EAST JIMMY CAMP INTERCEPTOR SANITARY SEWER CONSTRUCTION PLANS

COVER SHEET

DATE
SEPTEMBER 8, 2017

SHEET NUMBER
C1.1

OVERALL SITE MAP
EAST JIMMY CAMP CREEK INTERCEPTOR

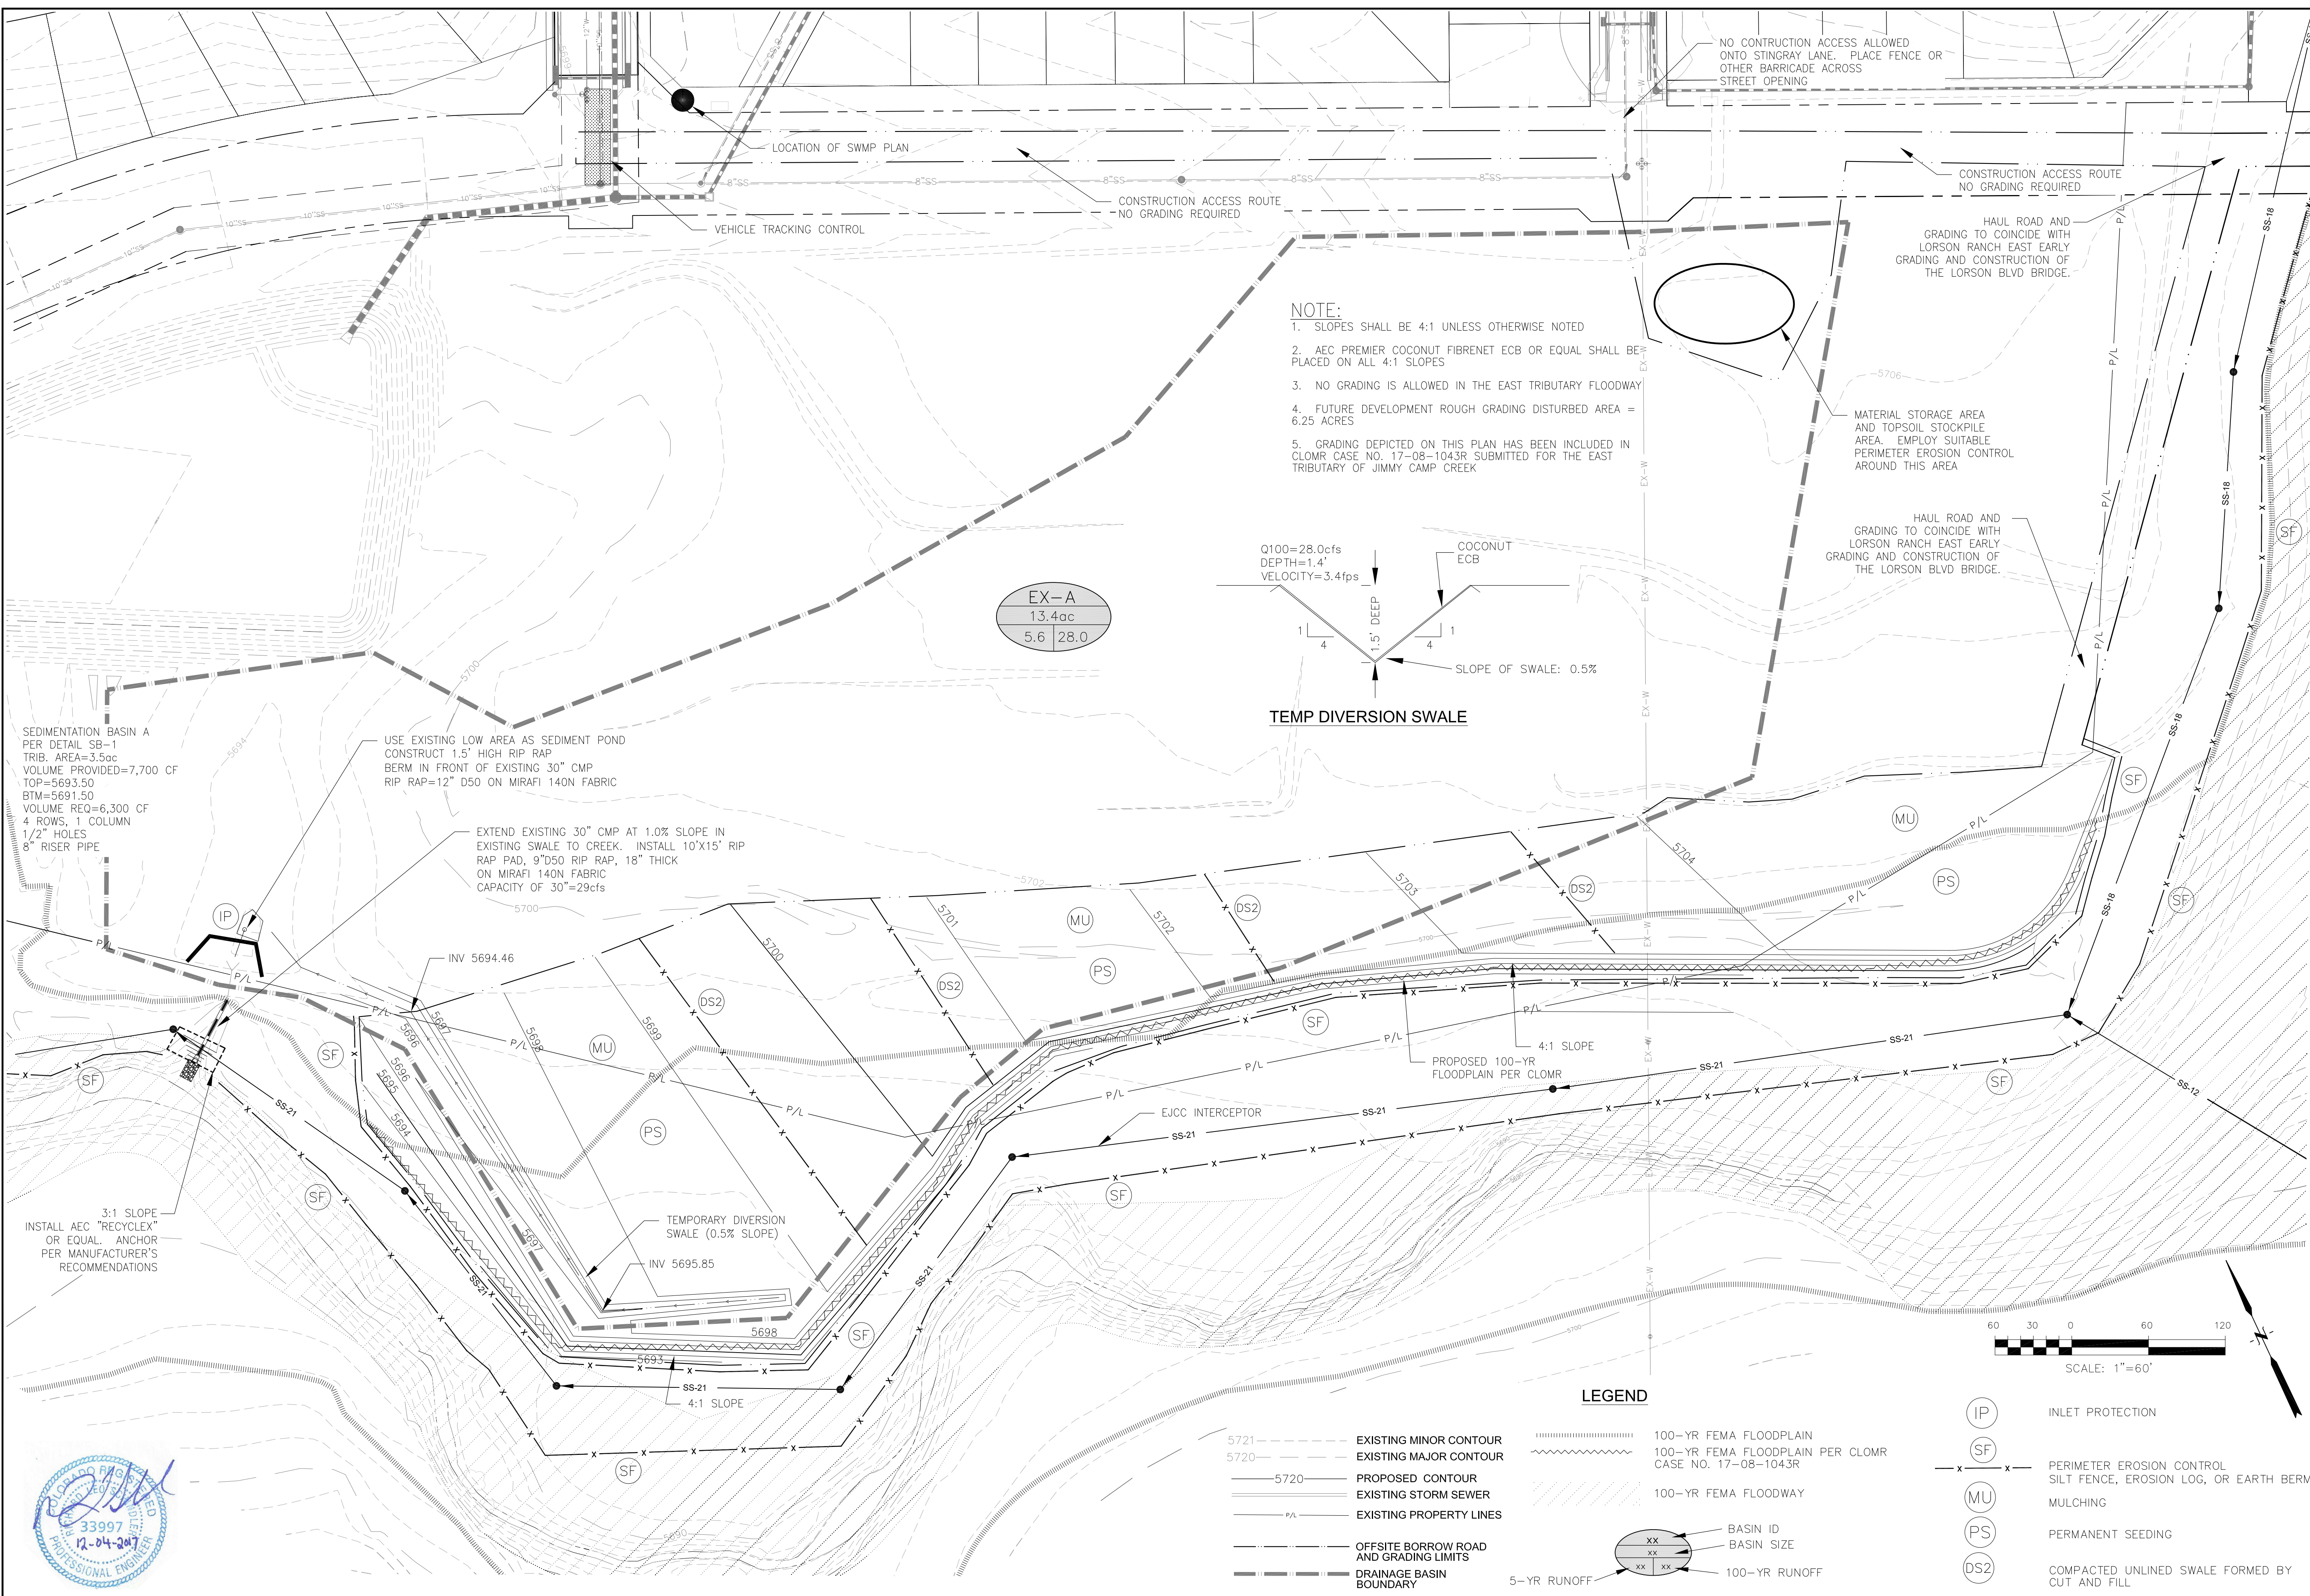
Provide a GEC details sheet
